WEST SUSSEX COUNTY COUNCIL CONSULTATION

TO:	Arun District Council FAO: Anita Gardner
FROM:	Highways, WSCC
DATE:	18/06/2018
LOCATION:	The Laurels, Dappers Lane, Angmering, BN16 4EN
SUBJECT:	A/74/18/OUT Outline Planning Permission with all matters reserved, except access, for the demolition of existing outbuildings and the erection of 9No. two storey dwellings consisting of 2No. two bedroom dwellings, 3No. three bedroom dwellings and 4No. four bedroom dwellings. Departure from the Development Plan.
DATE OF SITE VISIT:	
RECOMMENDATION:	☐ Advice ☐ Objection ☐ Modification ☒ No Objection ☐ More Information ☐ Refusal
S106 CONTRIBUTION TOTAL:	N/A

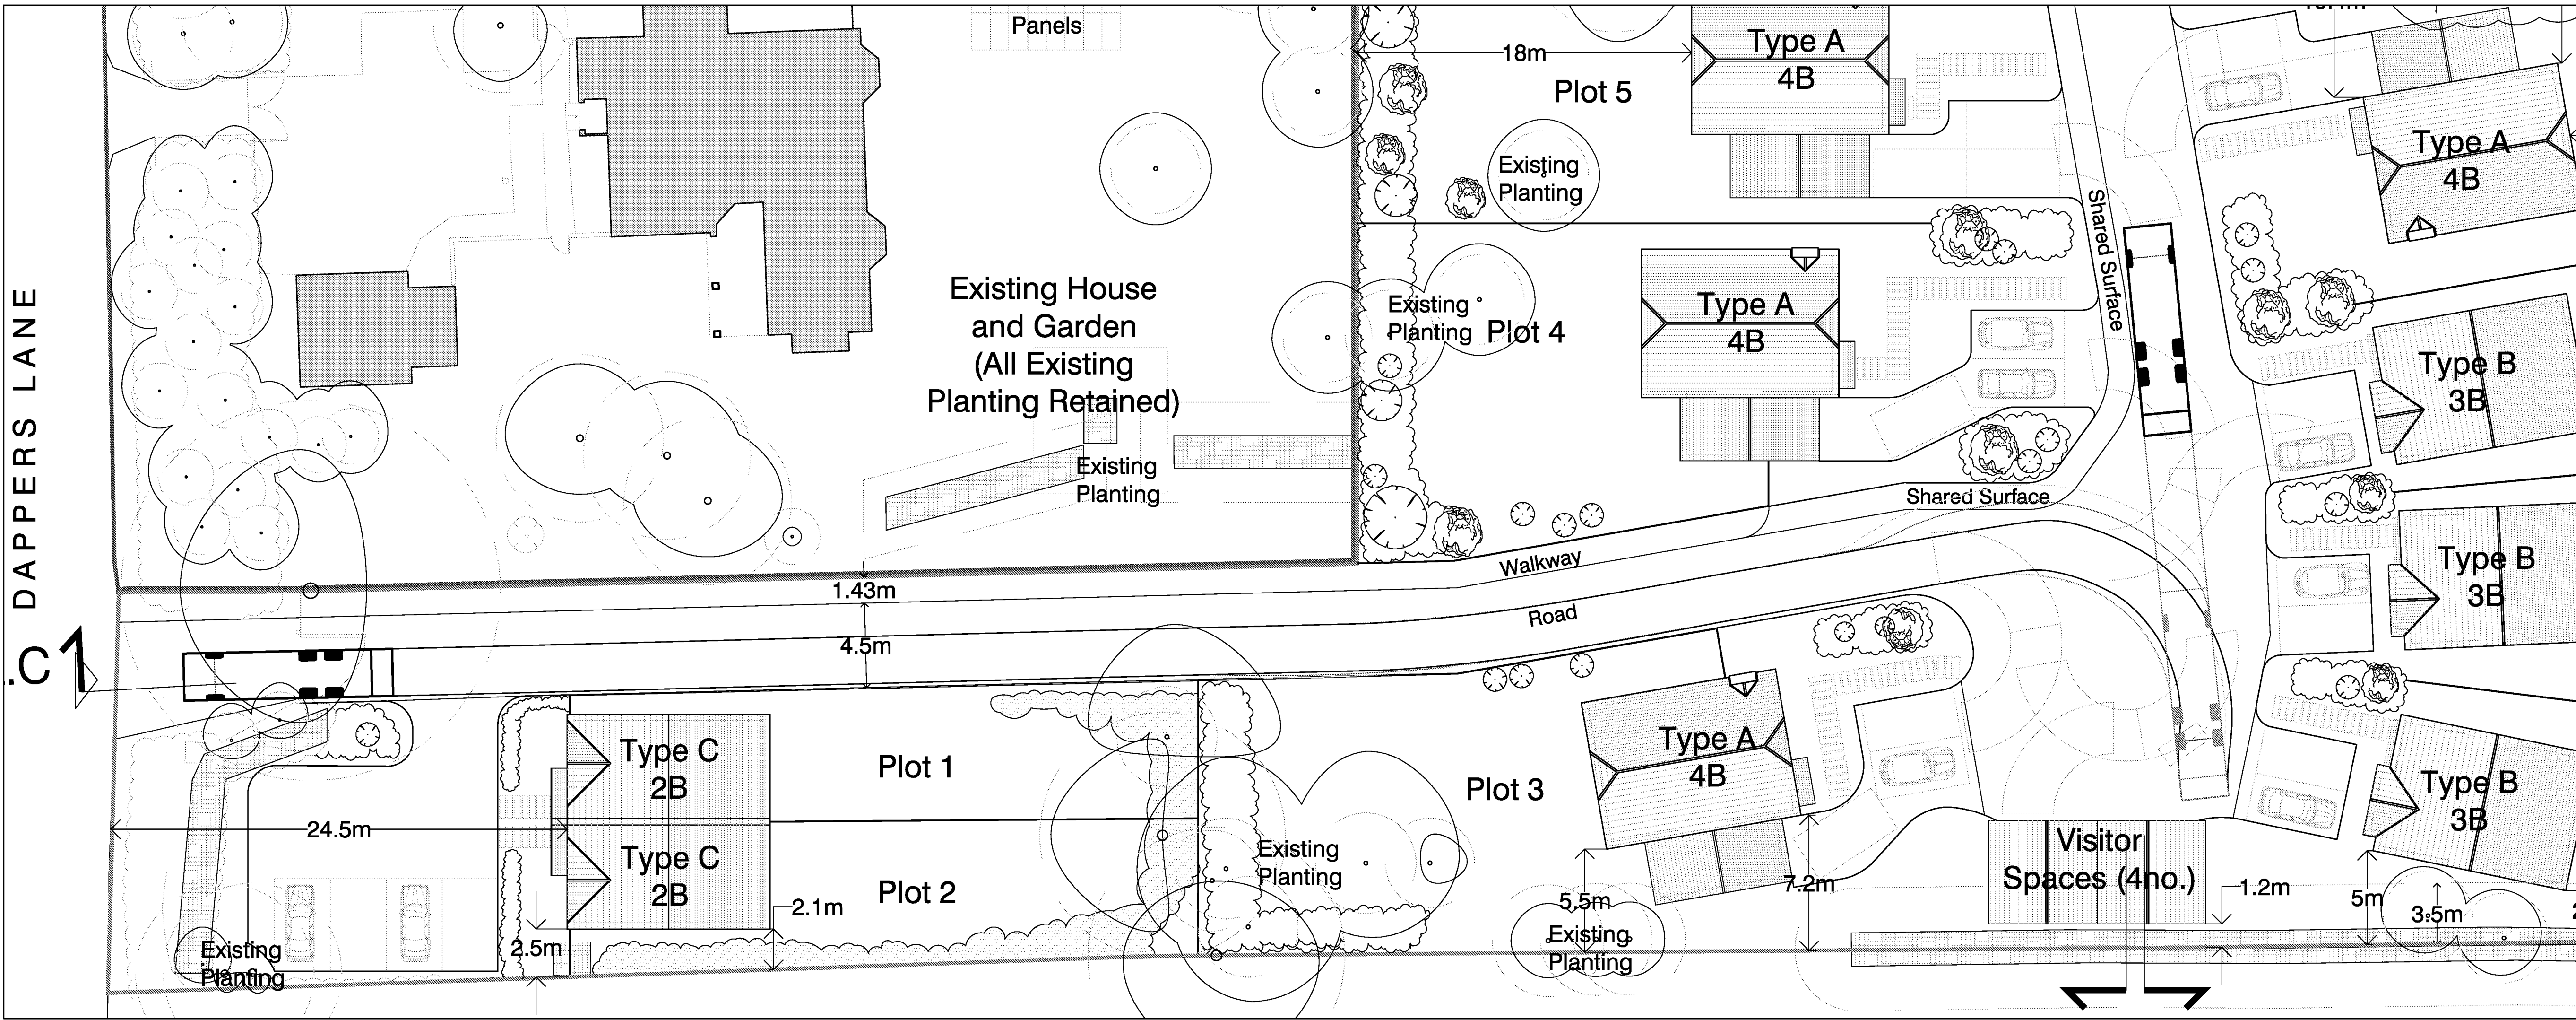
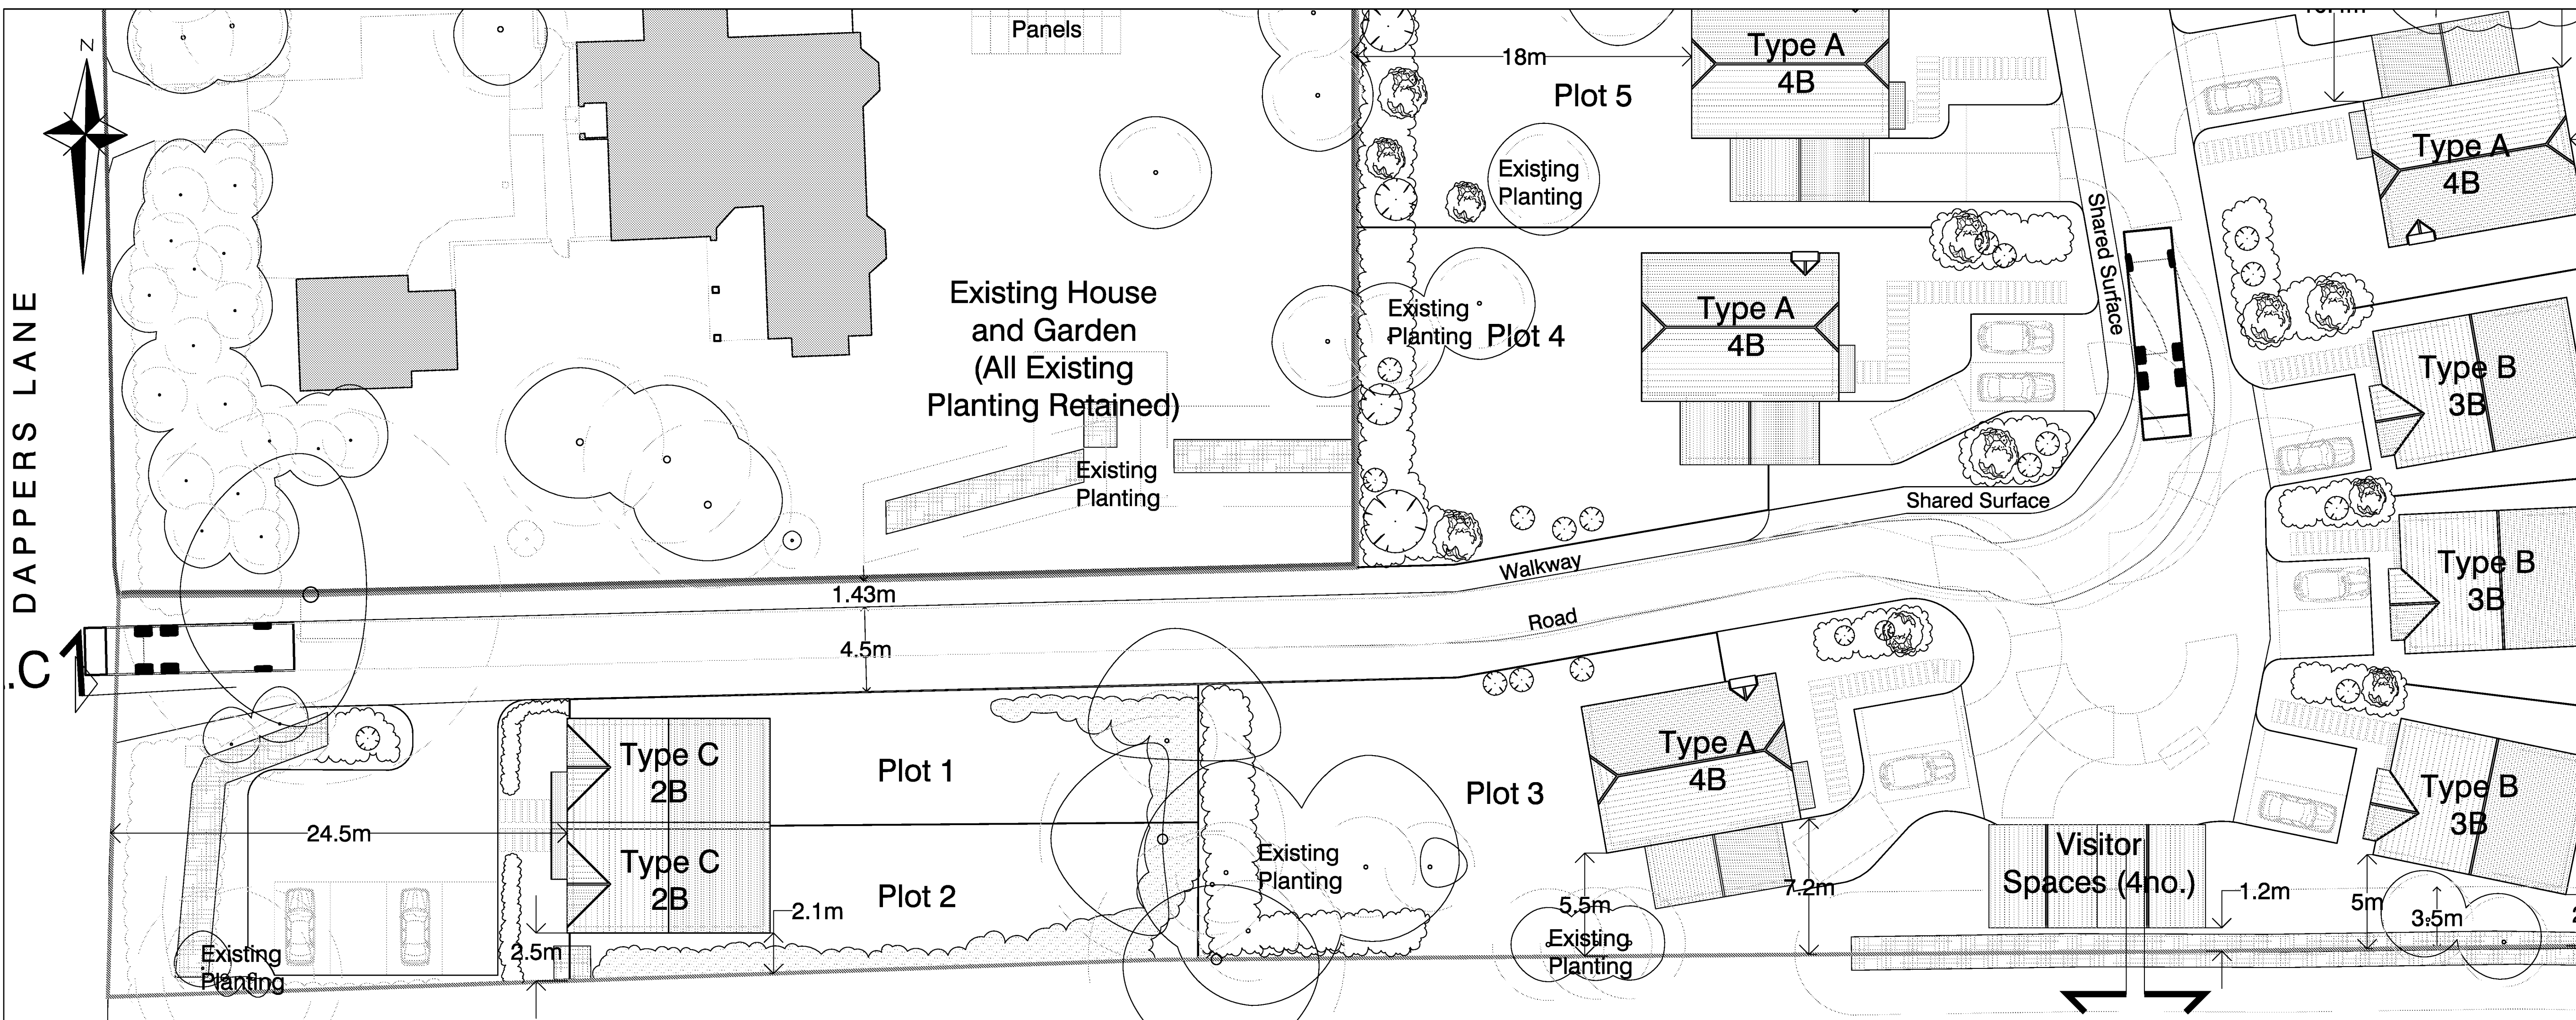
A review of the access indicates that, visibility is acceptable with the proposed amendments. There have been no recorded accidents within the last 3 years therefore there is no evidence to suggest the access and surrounding highway is operating unsafely at present. The TS demonstrates that large vehicles are able to enter and exit the site in forward gear and although this requires the crossing of the carriageway centre point, such movement would be acceptable given the infrequent nature and low volume of traffic.

A total of 22 car parking spaces will be provided on site. This provision has been considered against the WSCC Parking Demand Calculator. The proposed provision does not exceed the requirement generated by way of the PDC. From checking and based on the proposed mix and tenure of the dwellings, the car parking provision is anticipated to satisfy the likely demands. Swept path diagrams have been provided demonstrating cars turning with the site, refuse collection will take place from Dappers Lane; the applicant should liaise with ADC's waste collection authority on the suitability of this arrangement.

Location: Visibility and sightlines from the proposed access

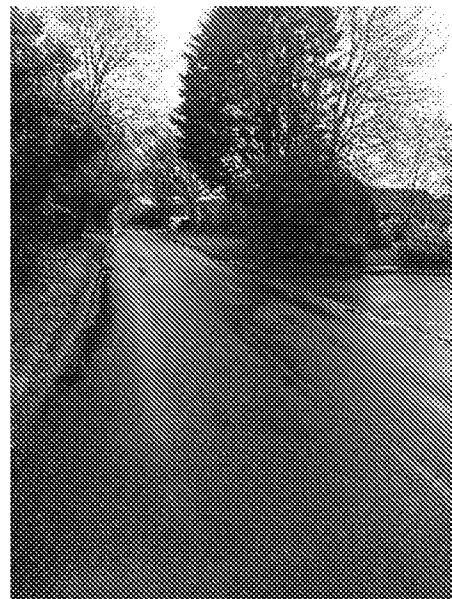
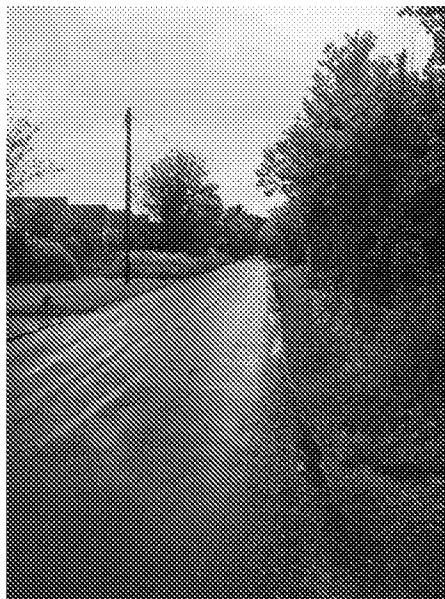
An upgraded access on to Dappers Lane is proposed. As the site accesses onto a "D" class road with a speed restriction of 30mph, it would be appropriate for the development to be considered alongside Manual for Streets (MfS) guidance. A Stage 1 RSA has been undertaken on the access arrangements. This identifies one problem (3.3.1) which related to restricted sight lines along Dappers Lane. The Designer confirms that the existing hedgerow will be cut back to obtain an acceptable level of visibility.

The proposed visibility splays, taken from a setback of 2.4 m, extend 43m to a point on the nearside carriageway line and this is consistent with MfS guidance. MfS does provide some allowance for occasional on-street parking within the visibility splay and it would appear that in this area, where most properties have some sort of off-street parking facility, that there is not an extensive demand for on-street parking particularly during peak movement time. It is considered that a suitable visibility condition can be applied in conjunction with the Designers Response to overcome the concerns of the Auditor on visibility.

No part of the development shall be first occupied until visibility splays of 2.4 metres by 43 metres have been provided at the proposed site vehicular access onto Deaks Lane in accordance with the approved planning drawings. Once provided the splays shall thereafter be maintained and kept free of all obstructions over a height of 0.6 metre above adjoining carriageway level or as otherwise agreed.
